Subject: Wastewater Capacity Application Approval for 415 Cumberland Ave

October 20, 2015

RE: The Capacity to Handle Wastewater Flows from 415 Cumberland Ave

5 Top Roof drainage plan
1/4" = 1'-0"

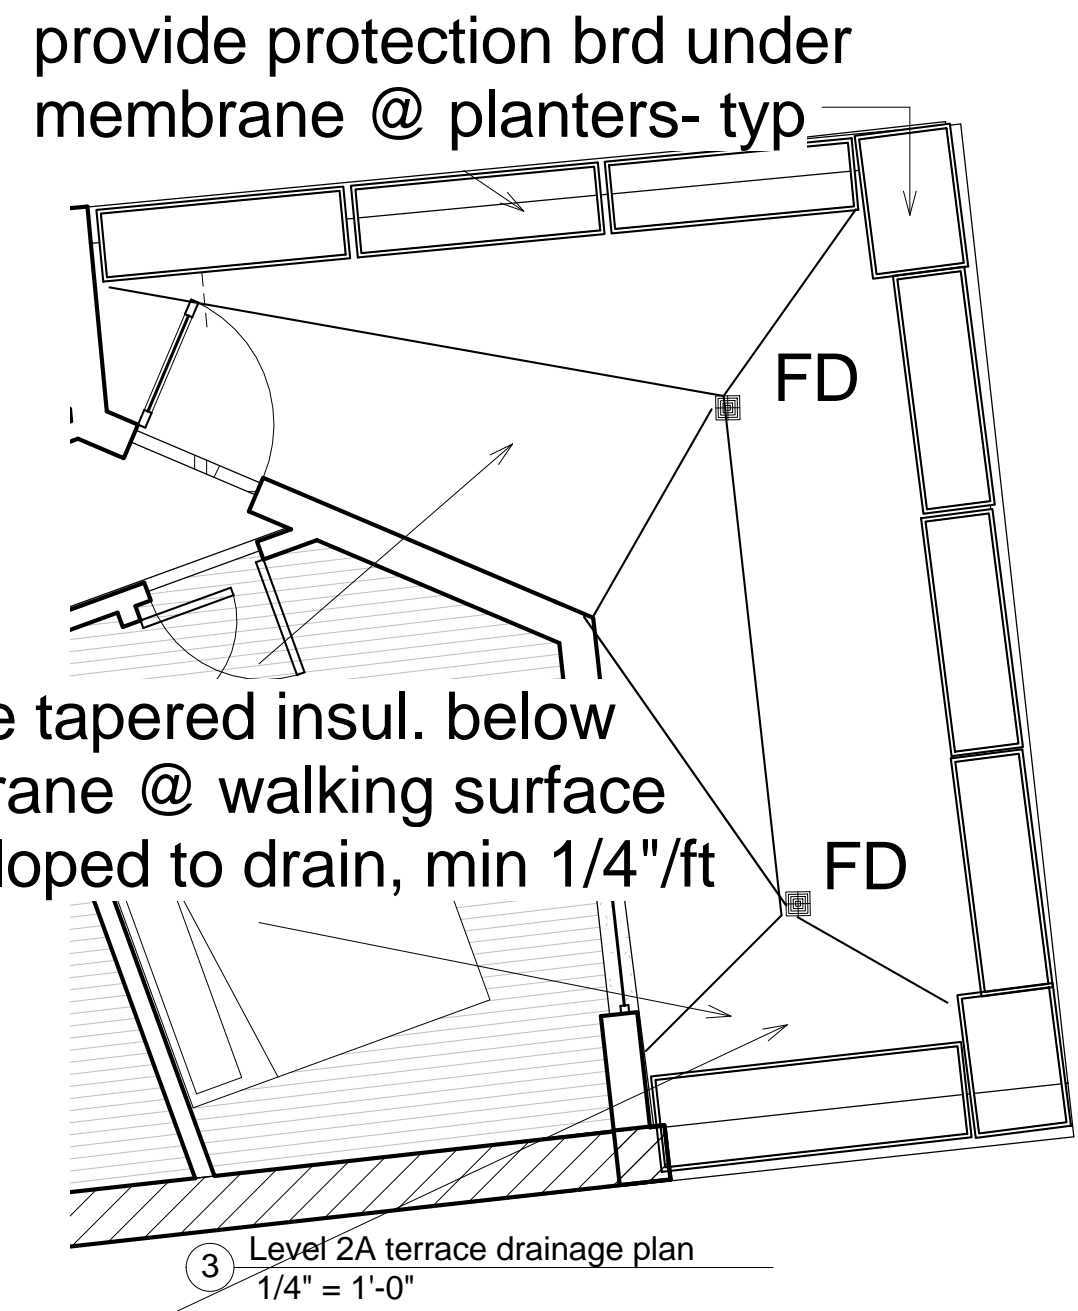
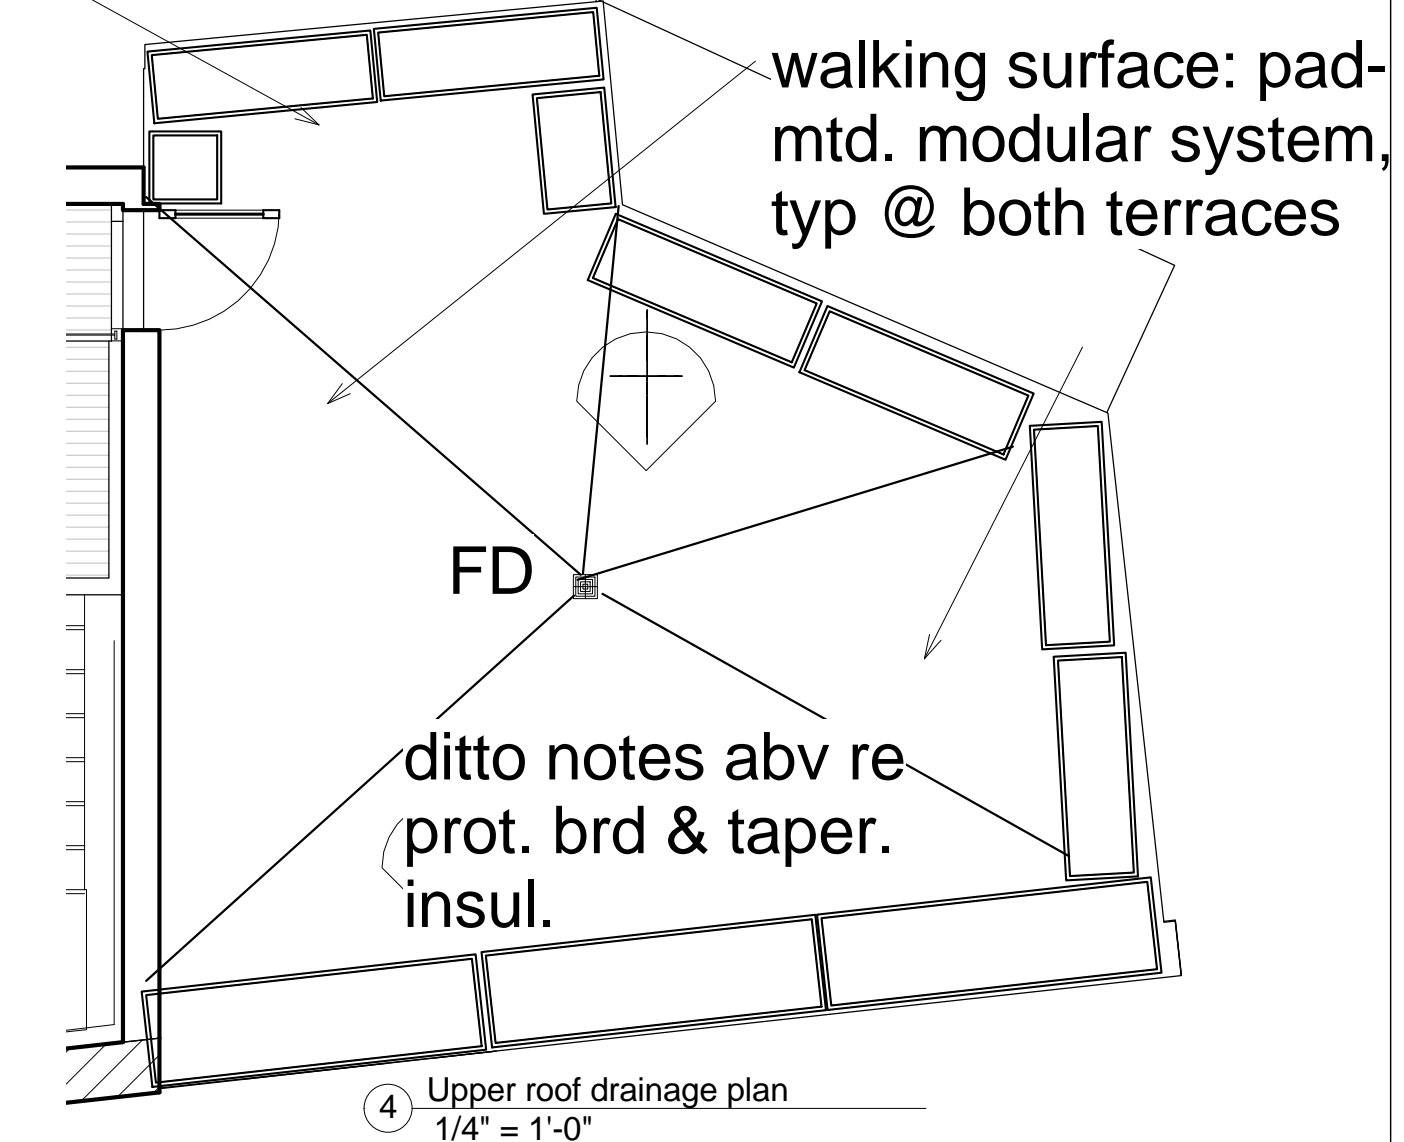
The Department of Public Services, which includes the Water Resource Division, has reviewed and determined that the downstream sewers from 415 Cumberland Ave has the capacity to convey the estimated 1,440 gallons per day of wastewater which will be generated from this multi family housing project. It is understood that no sources of stormwater runoff, roof drainage, or any other non-contaminated water shall be introduced to the wastewater collection system from this development. If roof drainage is currently discharging to the sanitary sewer system, we are requesting that the roof discharge be redirected to sidewalk or street level.
